From: Michael Eastham <Michael.Eastham@arun.gov.uk>
Sent: 17 May 2021 12:16
To: Planning.Responses <Planning.Responses@arun.gov.uk>
Subject: FW: Land at Water Lane, Angmering - Updated Landscape Plans - A/31/21/PL, A/67/21/PO and A/39/21/DOC

From: Sue Howell <Sue.Howell@arun.gov.uk>
Sent: 17 May 2021 10:58
To: Michael Eastham <Michael.Eastham@arun.gov.uk>
Subject: RE: Land at Water Lane, Angmering - Updated Landscape Plans

Please find attached the revised landscaping and planting plans for **A/31/21/PL**, **A/67/21/PO** and **A/39/21/DOC**.

- Updated Landscape Masterplan (Rev. M)
- Updated Detailed Planting Plan, Sheet 1 (Rev. H)
- Updated Detailed Planting Plan, Sheet 2 (Rev. H)
- Updated Detailed Plant List, Sheet 8 (Rev. H)

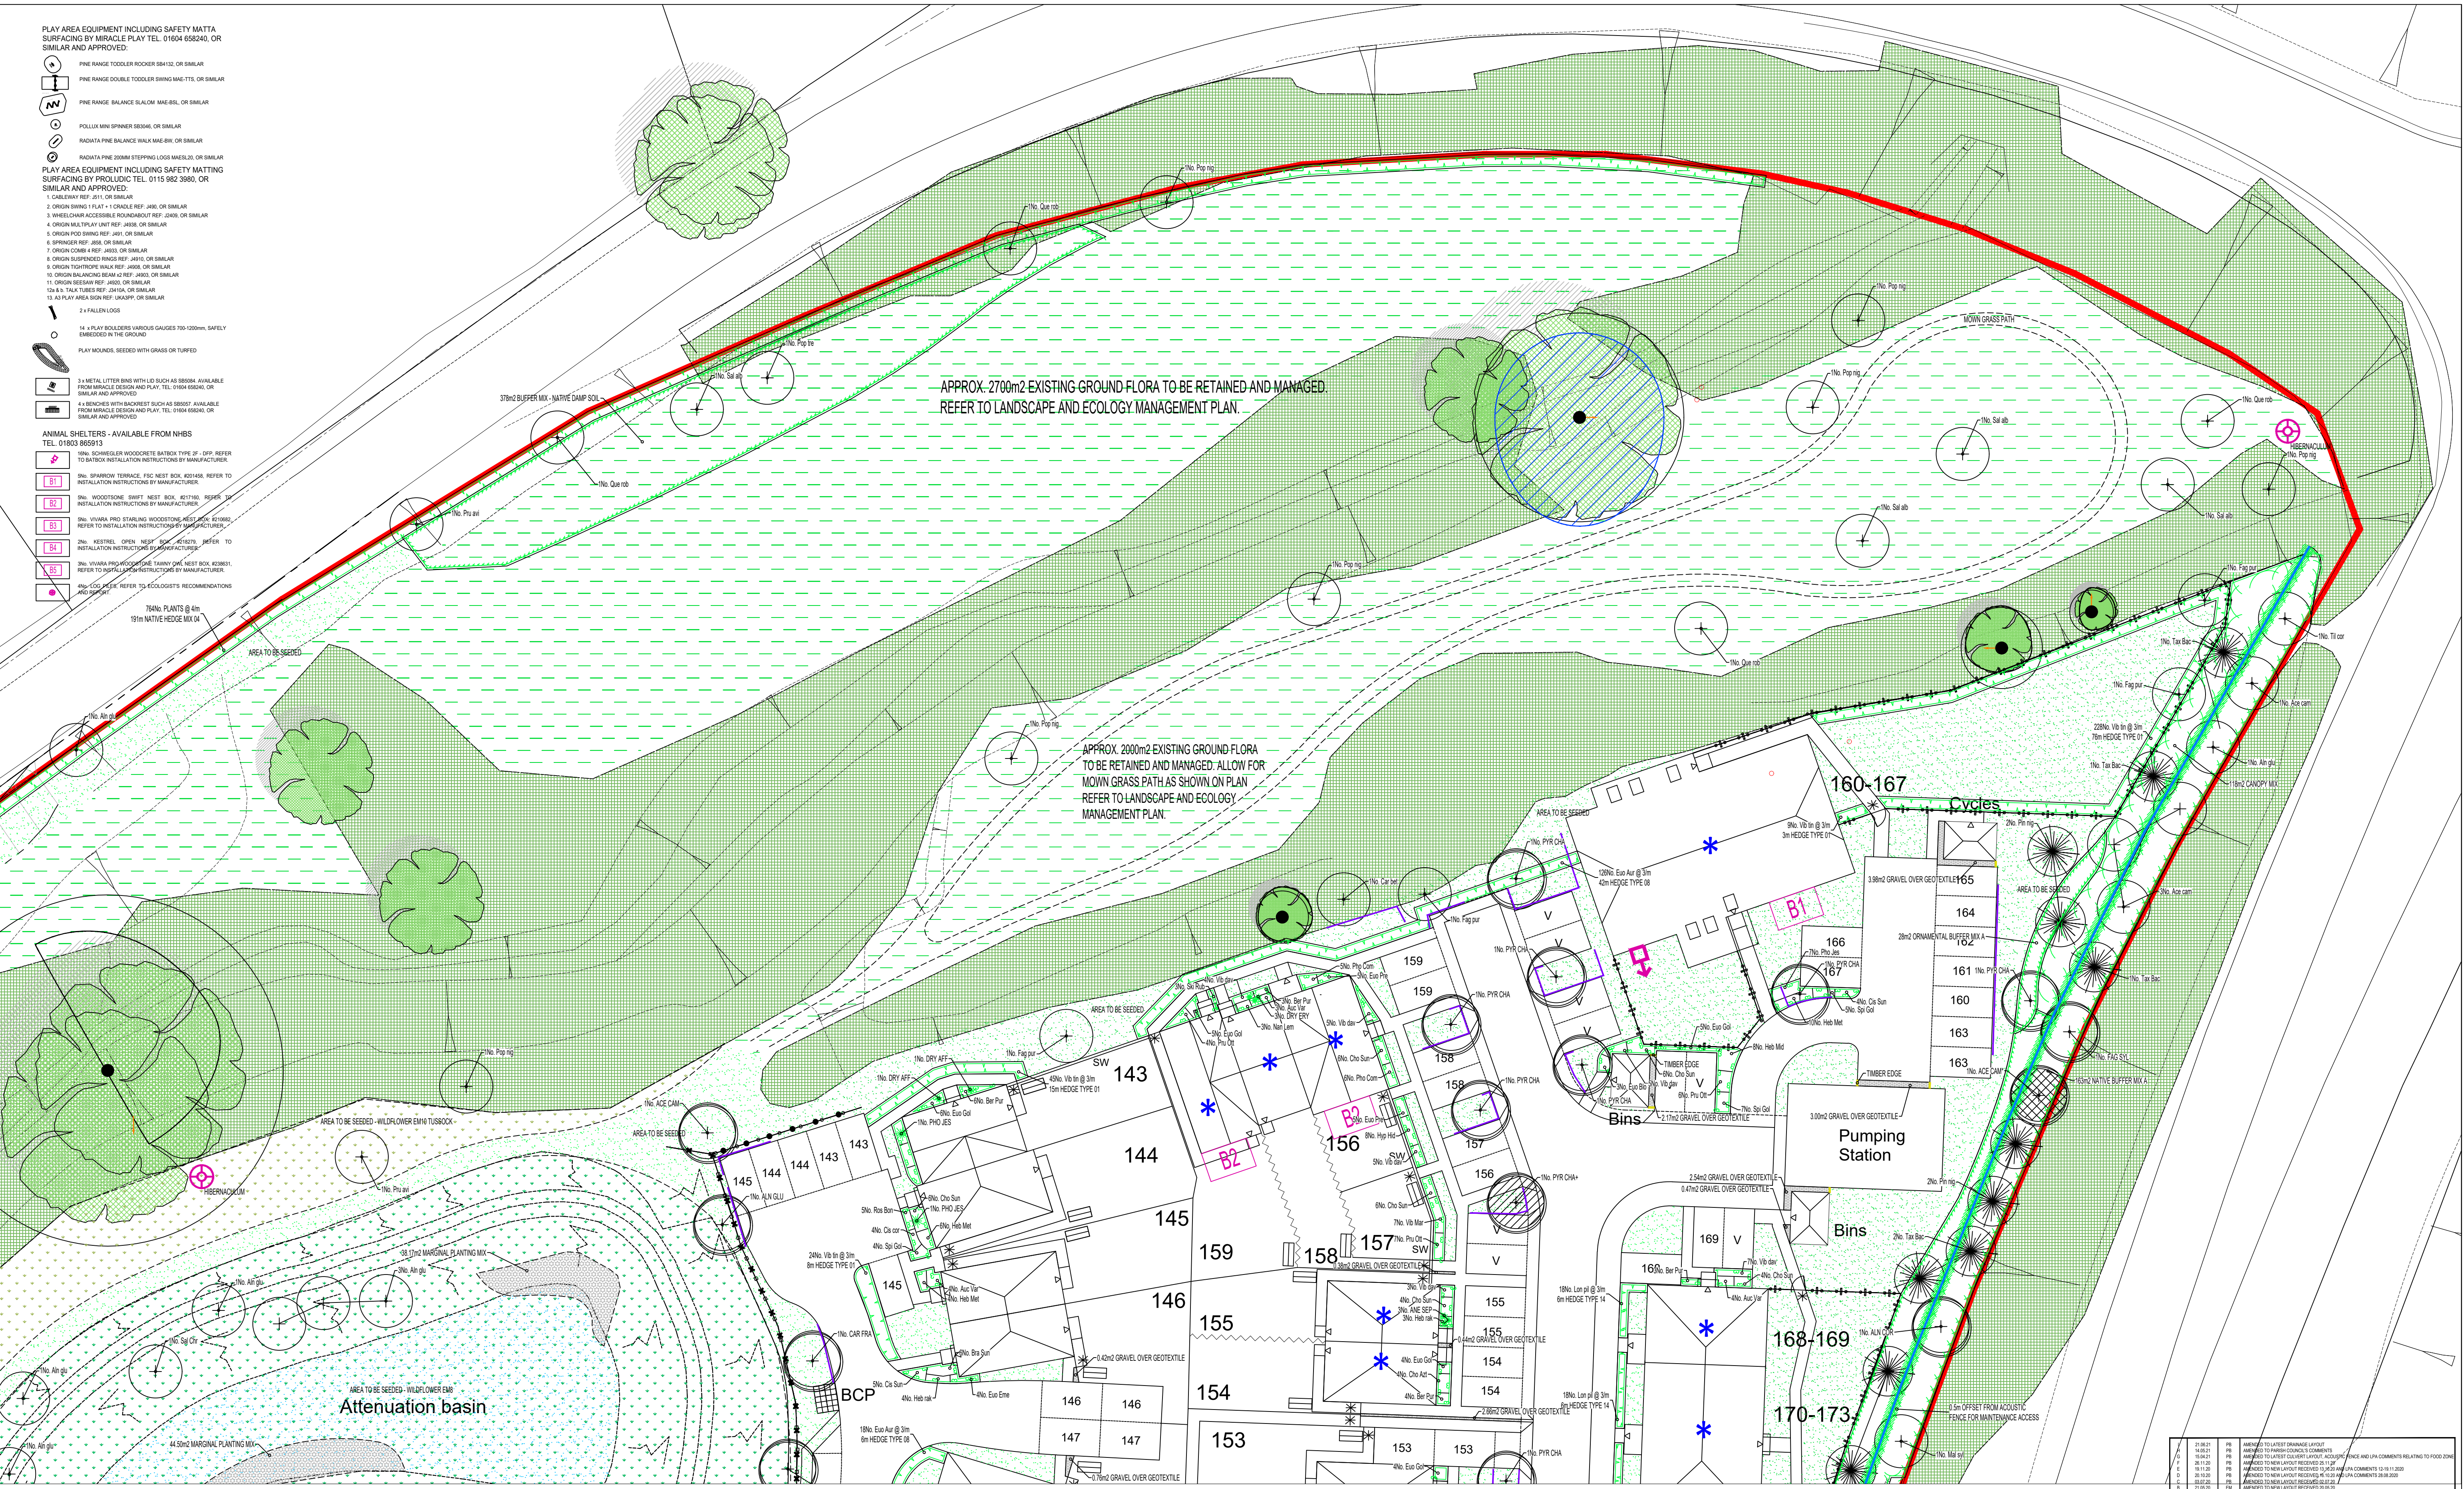
The revisions below appear to relate to Parish Council Comments and as far I can decipher specifically hedgerow location in relation to boundary. These would appear satisfactory assuming no conflict with visibility or sight line splays.

As discussed during the meeting, we have moved the hedgerow as close to the boundary as possible whilst taking into account the visibility splays.
